Sea Link Energy Cable

**Appendix K5 to the Natural England Deadline 5 Submission.
Natural England's comments on the Examining Authority's Written Questions 2 [PD-
021]**

Planning Inspectorate Reference EN020026

11th March 2026

**Plate 3.2 Preferred area of acid grassland enhancement**

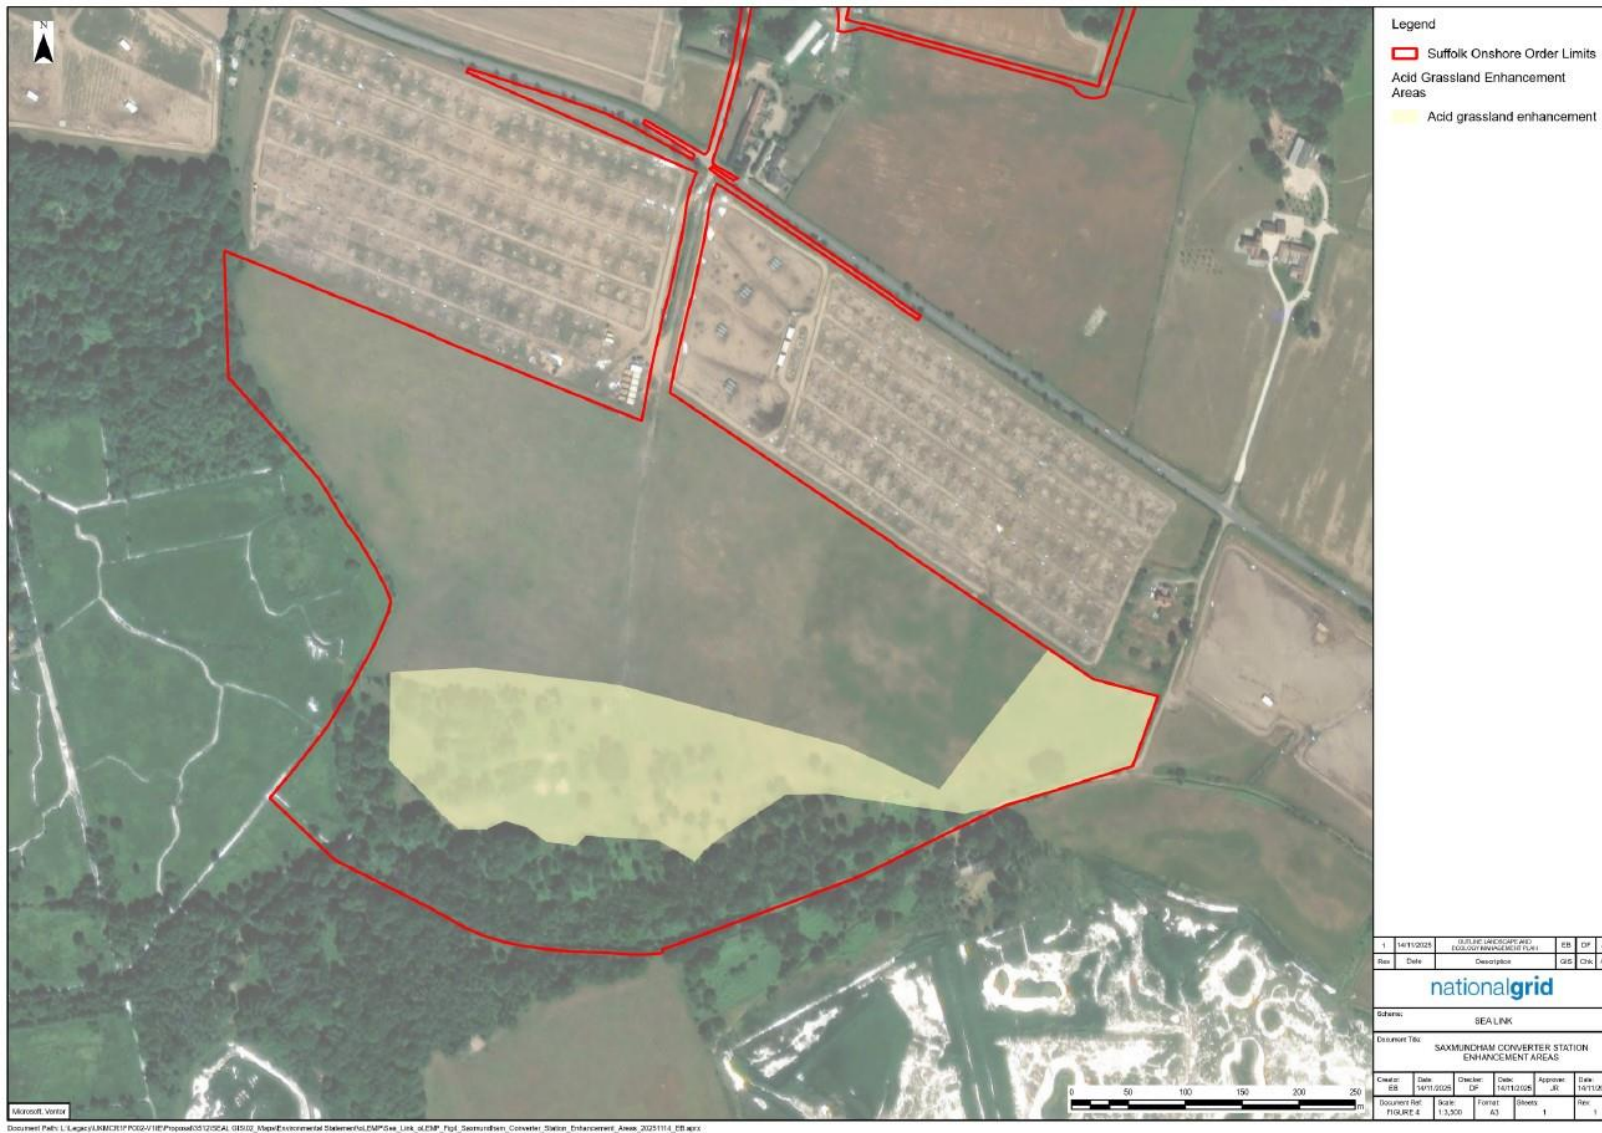
<p>would be affected, including the risks of reinstatement and the time taken to reach functionality. Include in this clarification whether works that have already been carried out to the golf course within the order limits have affected its quality as acid grassland and its reinstatement potential. For example, it is stated that the land has been affected by the golf course extension which has resulted in disturbance and reprofiling. Provide further detail, including a plan, as to the extent to which land within the order limits has been directly affected by the golf course extension. Clarify whether the 4.05ha of land within the extended golf course will be able to be reinstated as acid grassland if it is to be used as a golf course. Clarify how the land within the extended golf club will be restored to a higher quality than its current position. As the area of temporarily affected acid grassland is estimated by the applicant to be 7.06ha in [REP1-120], explain why only 6ha is provided as mitigation/compensation/ enhancement.</p> <p>NE: Paragraph 5.3.1 of the Suffolk outline Landscape and Ecological Management Plan (oLEMP) [REP4-065] suggests that good quality acid grassland is a priority habitat under the Natural Environment and Rural Communities (NERC) Act 2006. Clarify whether the quality of acid grassland affects whether it should be considered a UK Biodiversity Action Plan Priority Habitat, as suggested by the applicant.</p>

2LVIA10	Applicant, ESC, SCC, SEAS and other relevant stakeholders	<p>Cumulative effects on the AONB</p> <p>Applicant: The updated assessment of effects on the sub-factors of the special qualities and natural beauty indicators set out in the Planning Statement Addendum [REP4-092] is welcomed. The cumulative assessment provided in table 4.1 of the National Landscape Section 85 Duty Technical Note [REP1-</p>	<p>It is not clear where compensation for significant cumulative impacts has been addressed.</p> <p>The <i>National Landscape Section 85 Duty Technical Note [REP1-120]</i> relates to compensation for acid grassland loss during</p>

<p>120] is only in relation to the indicators rather than the sub-factors. Provide a more detailed cumulative assessment in relation to the sub-factors for the natural beauty indicators and special qualities indicators with a greater level of detail as to the factors that have led to the conclusions for each indicator and the magnitude of the effect. Where a temporary significant adverse effect is identified, specify the likely duration of the temporary effect and whether any avoidance, mitigation or compensation measures could be identified that would reduce the magnitude of the effects.</p> <p>ESC, SCC, SEAS and other relevant stakeholders: Suggest potential mitigation or compensation measures for the likely significant cumulative effects on the special qualities and natural beauty of the AONB, as identified in table 4.1 of [REP1-120].</p>	<p>construction and is limited to 10 years. We continue to raise concerns regarding the lack of clarity on the multifunctional use of this area of land.</p> <p>Natural England continues to advise that given the nature and location of the project within a National Landscape, it is not clear how alternatives to open trenching methods through the receiving landscape have been fully considered in line with the mitigation hierarchy. And where impacts can't be avoided every effort should be made to reduced impacts as much as possible.</p> <p>The mitigation hierarchy is considered at all stages of the Levelling-up and Regeneration Act 2023 duty in order to first avoid impacts to Protected Landscapes.</p>
